This letter is in support of the Variation of Condition application to vary Condition 2 of consent 3/21/1839/Ful. Condition 2 relates to the approved plans.

We therefore request the following variations to Condition 2 of Consent 3/21/1839/FULL:

- Change drawing P1004E to drawing P1004G
- Change drawing P1005 to drawing P1005B

Proposed Side Elevation
Scale 1:100 @ A1(East)

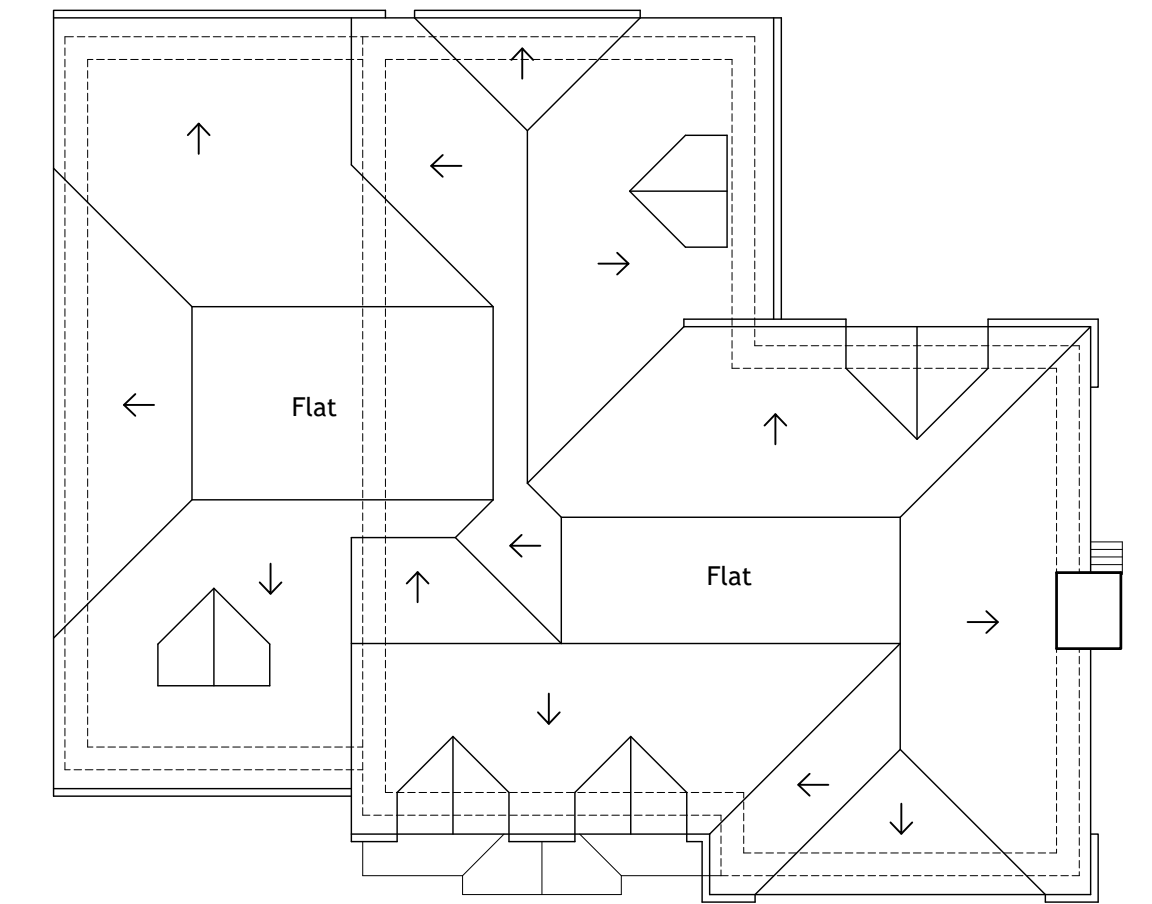
- External lounge wall moved South by 1m
- External kitchen/dining room wall moved South by 0.5m
- External kitchen/dining room wall moved West by 0.5m
- Two number windows added on West elevation at ground floor.
- Bifold door added on West elevation at ground floor.
- High level window added at first floor on East Elevation.
- Eaves and ridge raised above master bedroom on South elevation.
- Canopy added above ground floor door on East Elevation.
- Dentil brick course added above ground floor windows on all elevations.
- Chimney design revised on ground floor West elevation.
